**Fenwick Solar Farm
EN010152**

**Landscape and Visual Supplementary Report
Document Reference: EN010152/APP/8.23**

May 2025
Revision Number: 00

Drawing file: published-documents / EN010152-000186-6.2 Fig 10-6 Screened Zone of Theoretical Visibility Solar PV Site.pdf

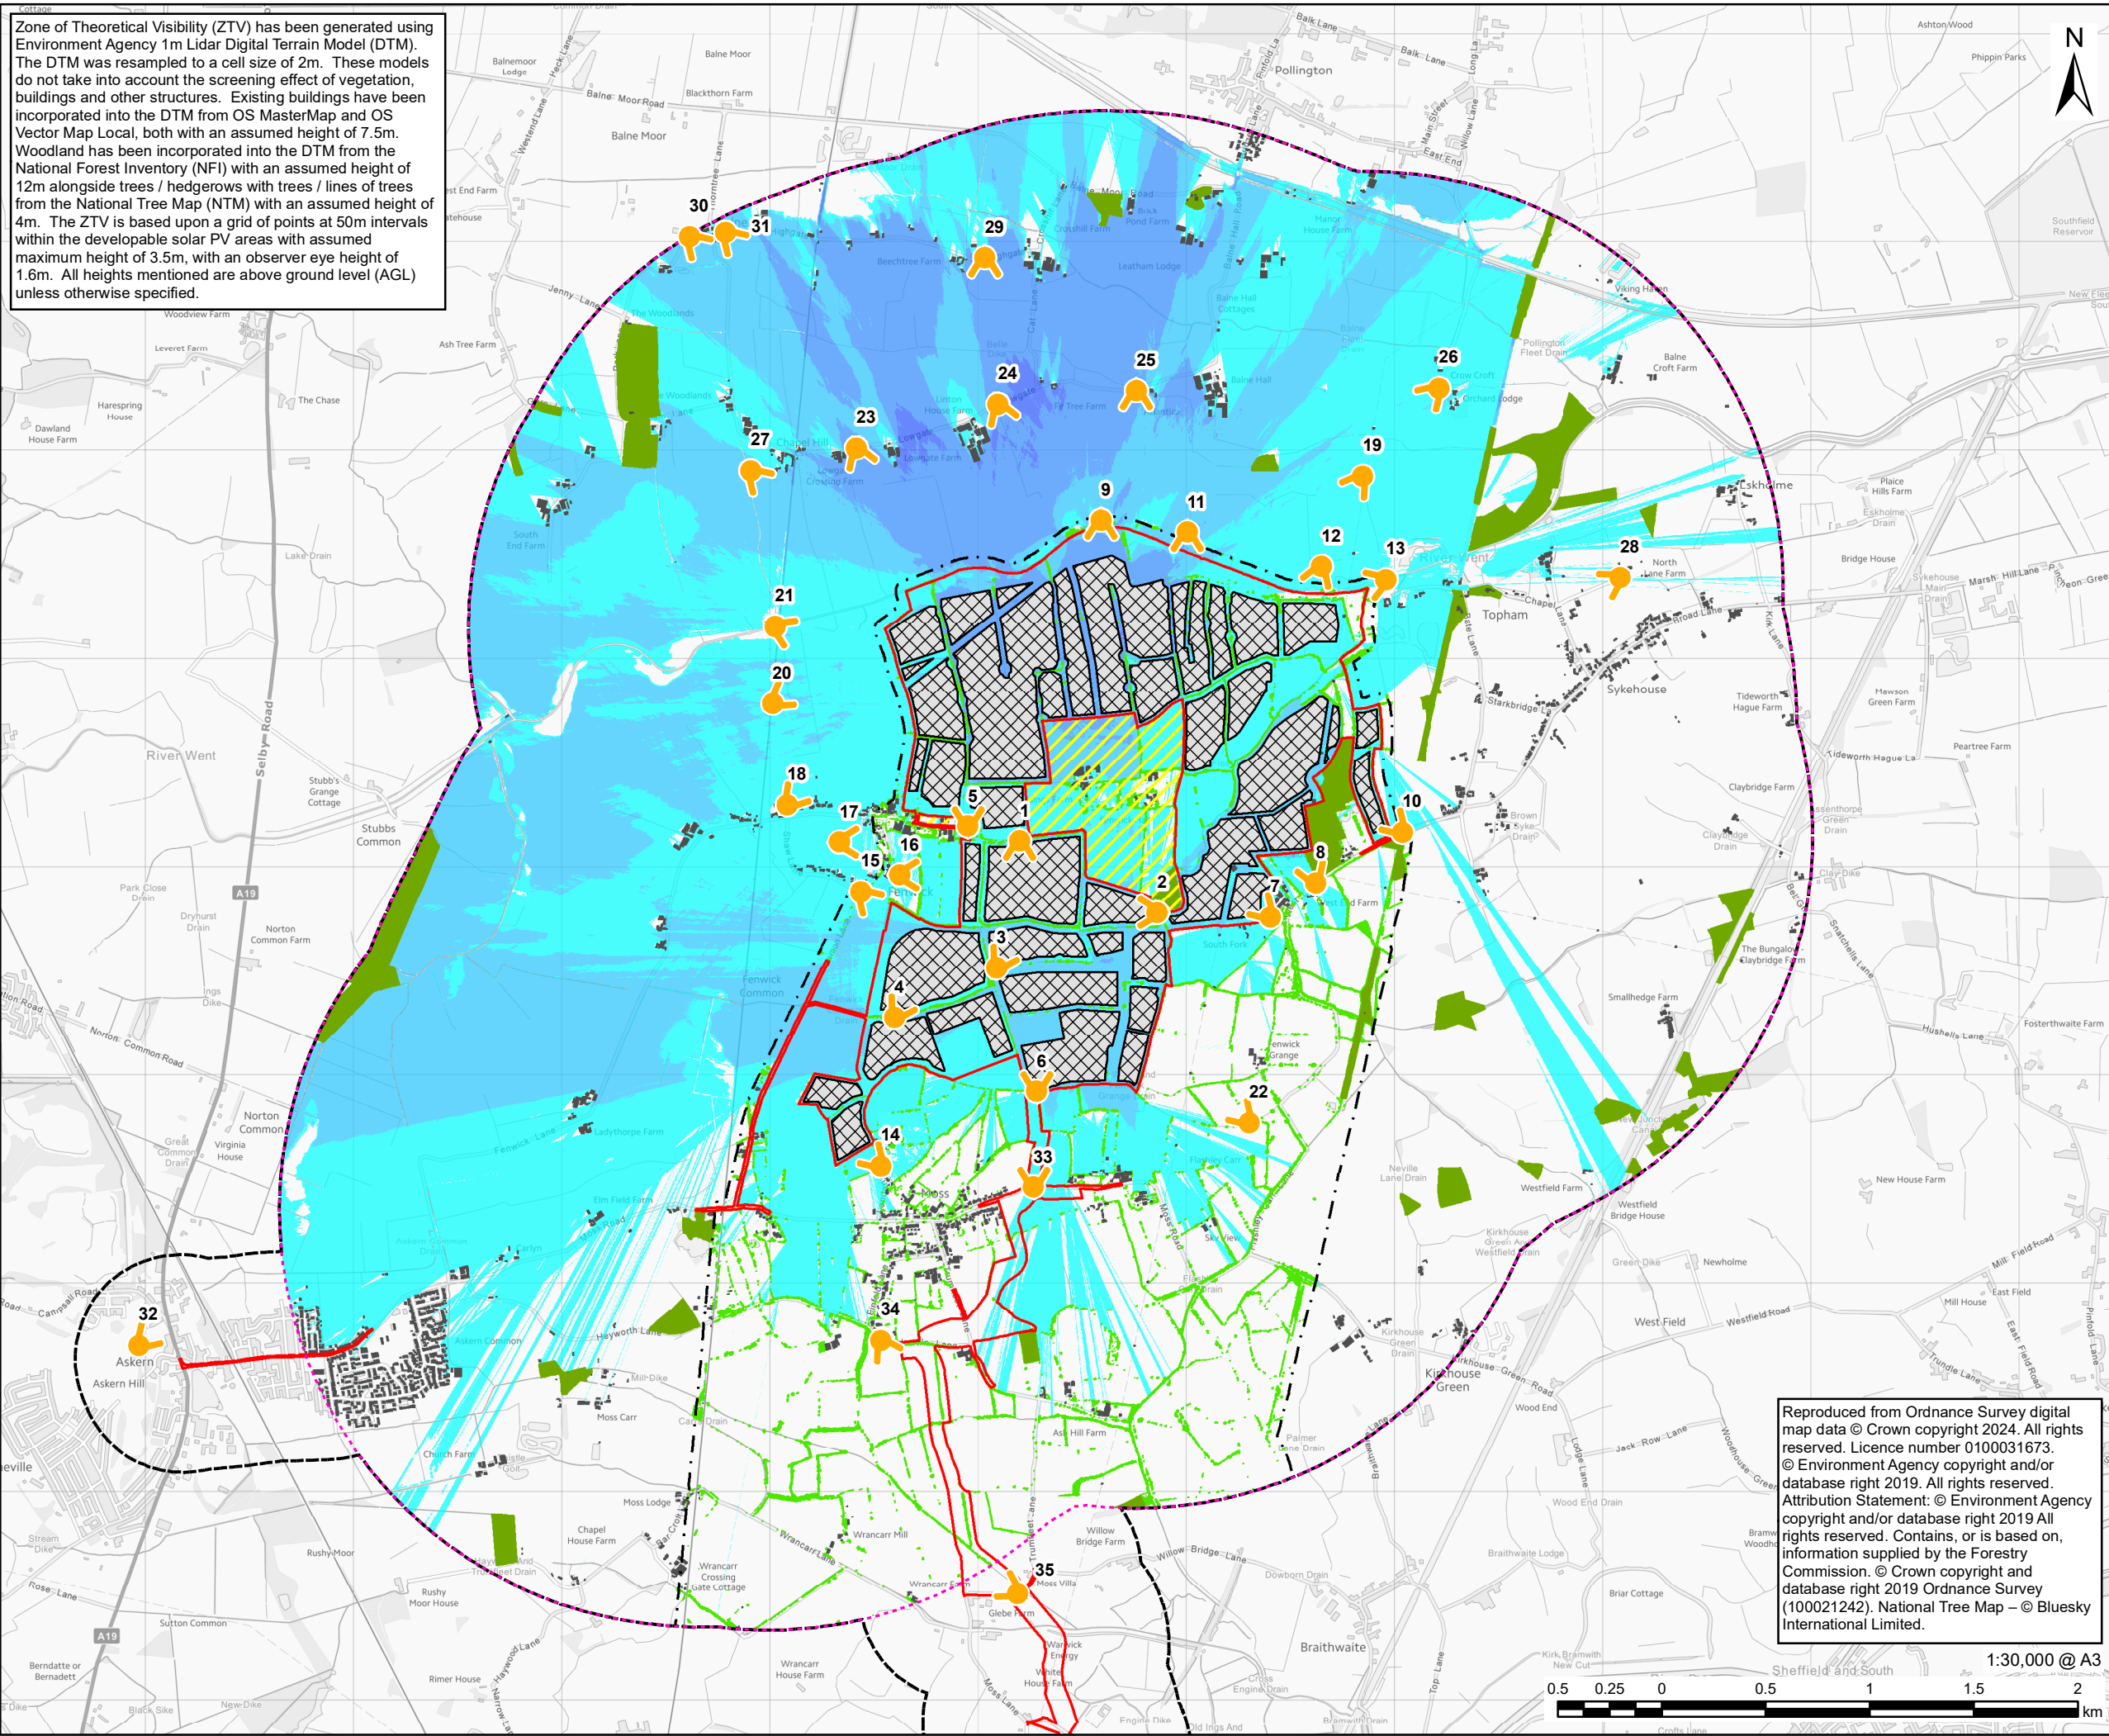
- 2.1.5 An updated ZTV and a bare earth ZTV will be provided following a request made by CDC. This will be provided in early to mid-May. These changes include:
- Extending the ZTV to the edge of the page as opposed to the Study Area;
 - Updates to representative viewpoint location symbology transparency to make base map more legible; and
 - Update to the transparency of the ZTV to make base map more legible.
